Sunnica Energy Farm EN010106

Suffolk County Council Response to the Updated Framework Construction Traffic Management Plan and Travel Plan (FCTMP&TP) (APP3-014) Deadline 4

16 December 2022

SUNNICA EAST SITE B,
SITE ACCESS I (SE-I)
NEWMARKET ROAD

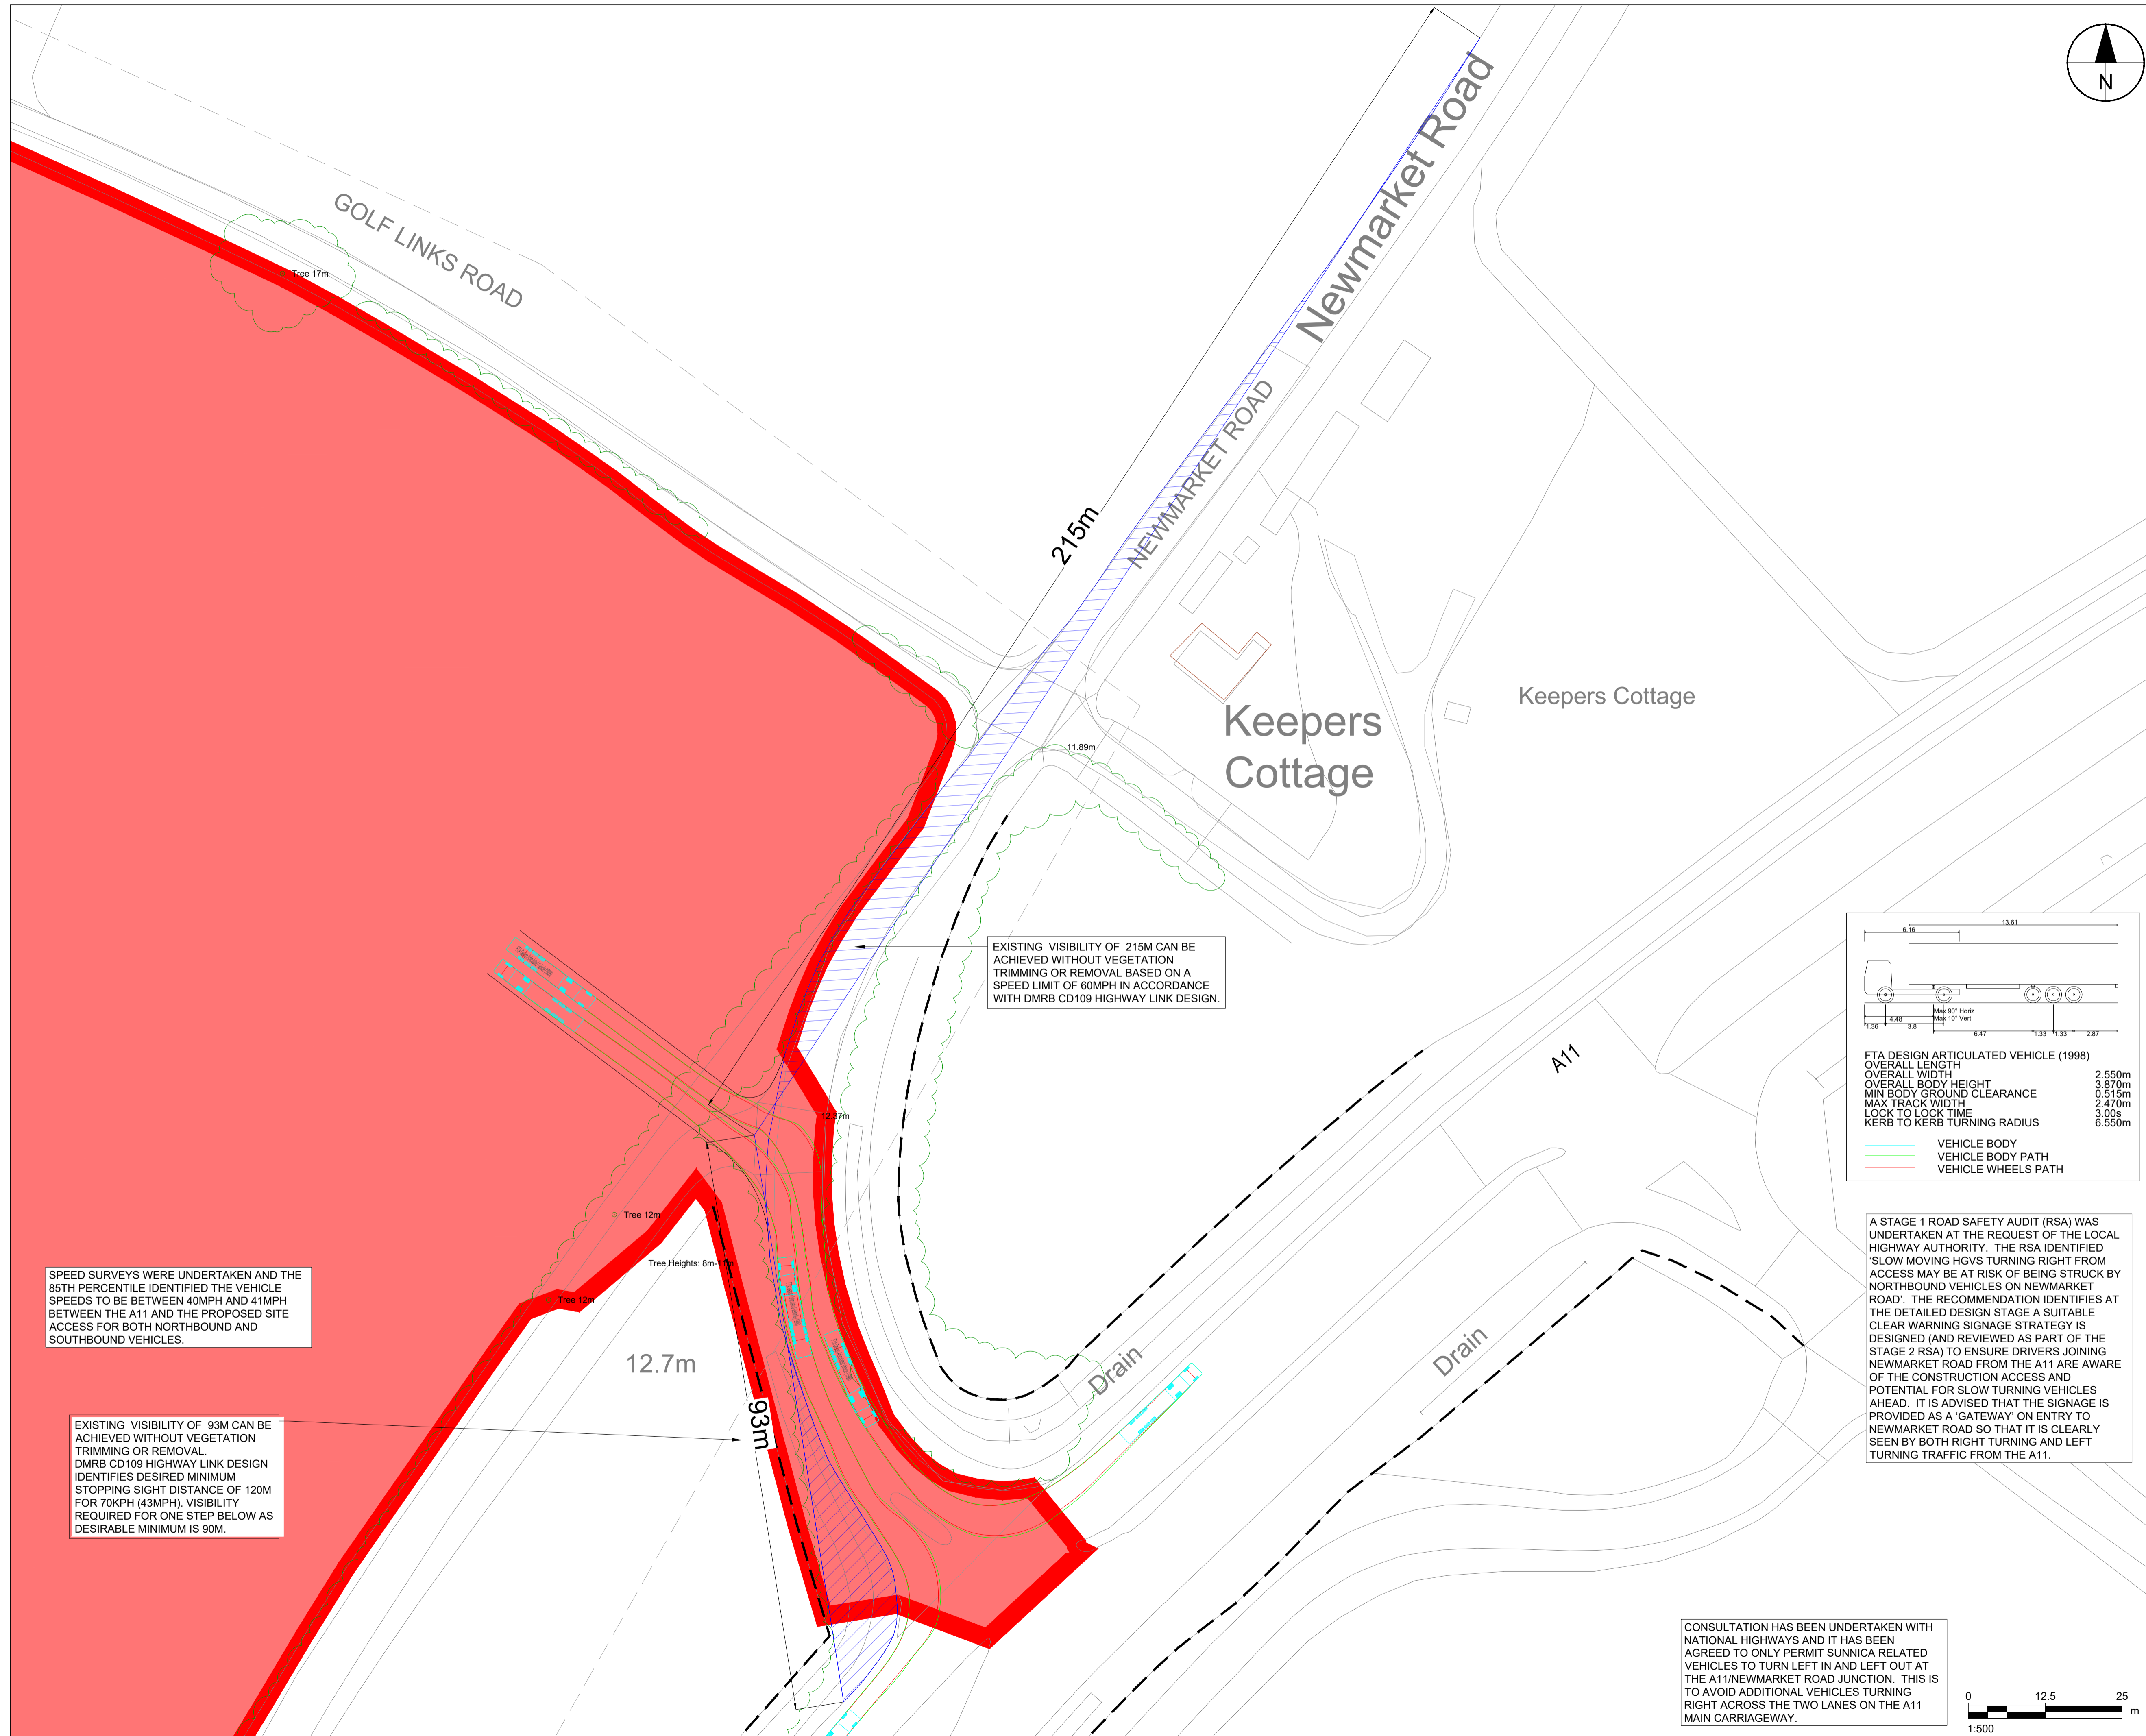
With regards to the road safety audit undertaken at access I (C576 Newmarket Road) described in paragraphs 5.11.3 to 5.11.8, SCC does not accept that the recommendation for additional temporary signing alone is sufficient to address the Council's concerns regarding the safety of this access, as notably the visibility towards the A11 is only 90m. The Applicant has not yet shared the designer's response to the safety audit with SCC nor updated the transport assessment with the speed data for this location (although it has provided this data to SCC).

13.72 The Applicant's proposals for a departure from the standard for the visibility at Sunnica East access I are discussed separately in this response.

Plate 6: Bend on B1102 The Street / Mildenhall Road

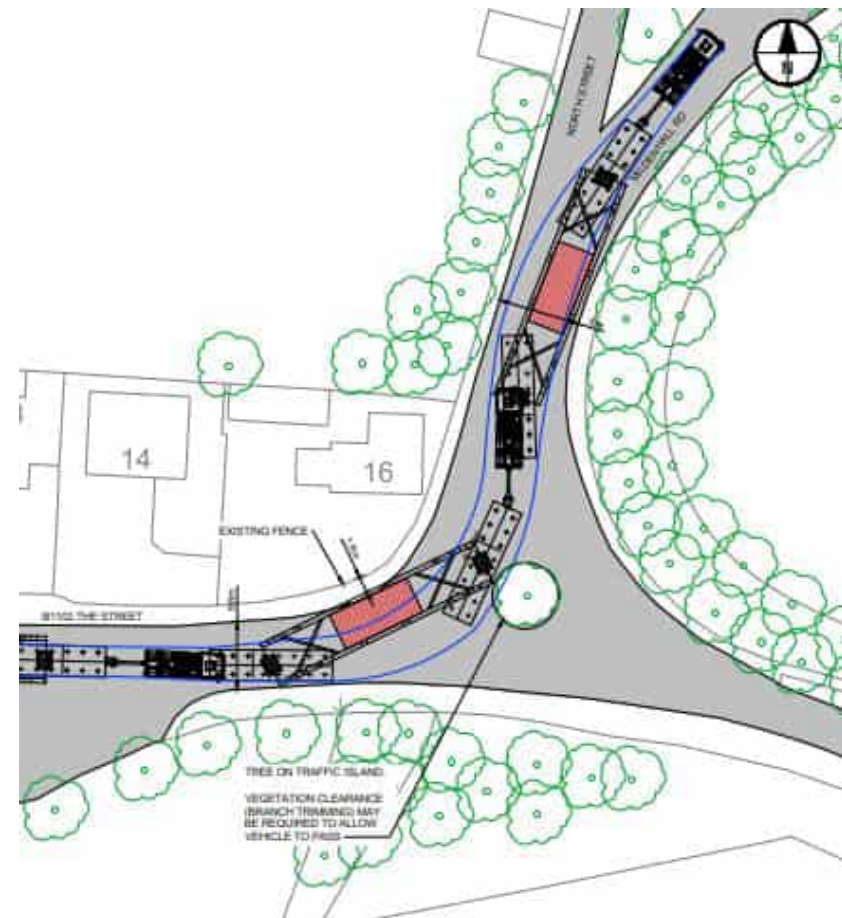
The Council notes that the Applicant has used an experienced contractor that has identified the maximum size of AIL vehicles accessing the site, but no similar experienced contractor appears to have been engaged to review the routes to the site. In other DCOs, notably EA1(N) this information was provided to the examination (<https://infrastructure.planninginspectorate.gov.uk/wp-content/ipc/uploads/projects/EN010077/EN010077-001388-6.3.26.3%20EA1N%20ES%20Appendix%2026.3%20Abnormal%20Indivisible%20Load%20Access%20to%20Onshore%20Substation.pdf>). We have referred to concerns raised about the movement of AILs and suitable routes in our LIR 13.55 to 13.58 (REP1-024). Also as noted in the LIR (REP1-024) the AIL wheel track (blue for AILs) passes over the central island at the junction of the B1102 The Street / Mildenhall Road (Plate 27) so more than trimming of branches (5.6.11) may be required at this location.

Plate 11: B1103 Swan Lane / Oxford Street Junction

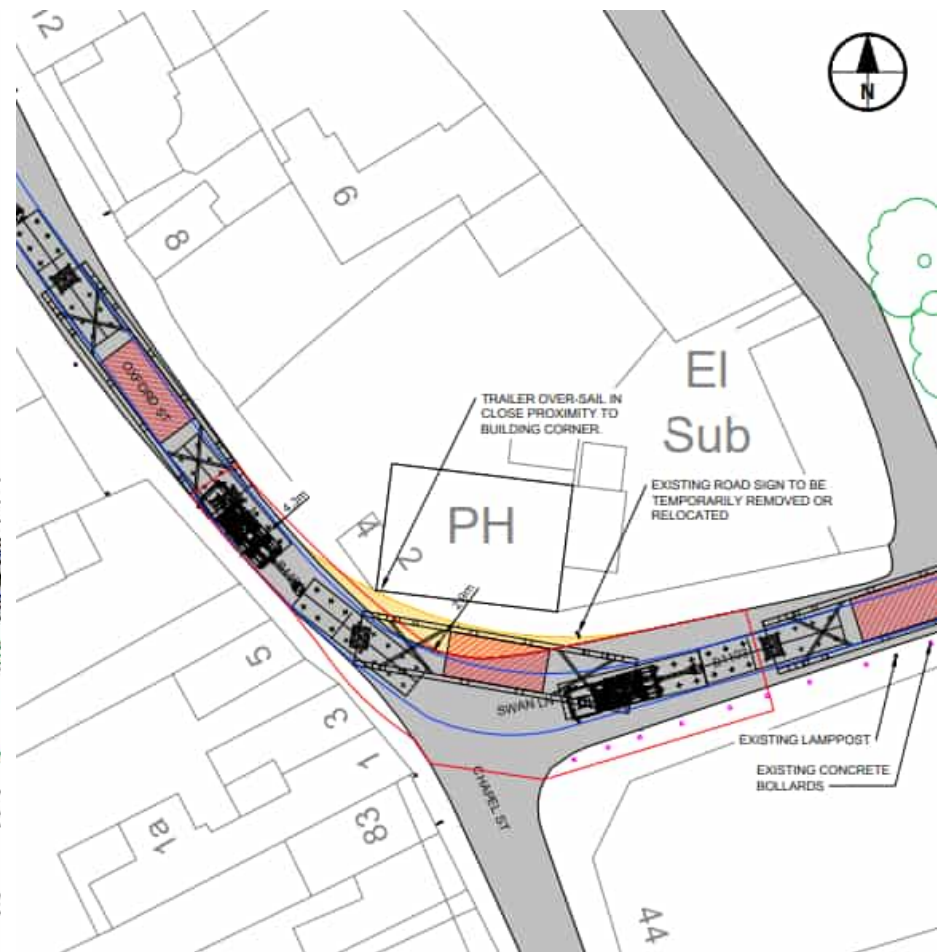
Comments have also been made regarding movements of AILs on the B1103 Swan Lane specifically the oversailing loads being very close to the White Swan Public House. It is noted that in paragraph 5.8.1, the Applicant acknowledges that a 1000 tonne crane will have to traverse parts of the footway. This is a concern to the LHA as it is not known what services are beneath the footway or how quickly any damage to these or the footway will be rectified. That this occurs raises questions about the suitability of this route.
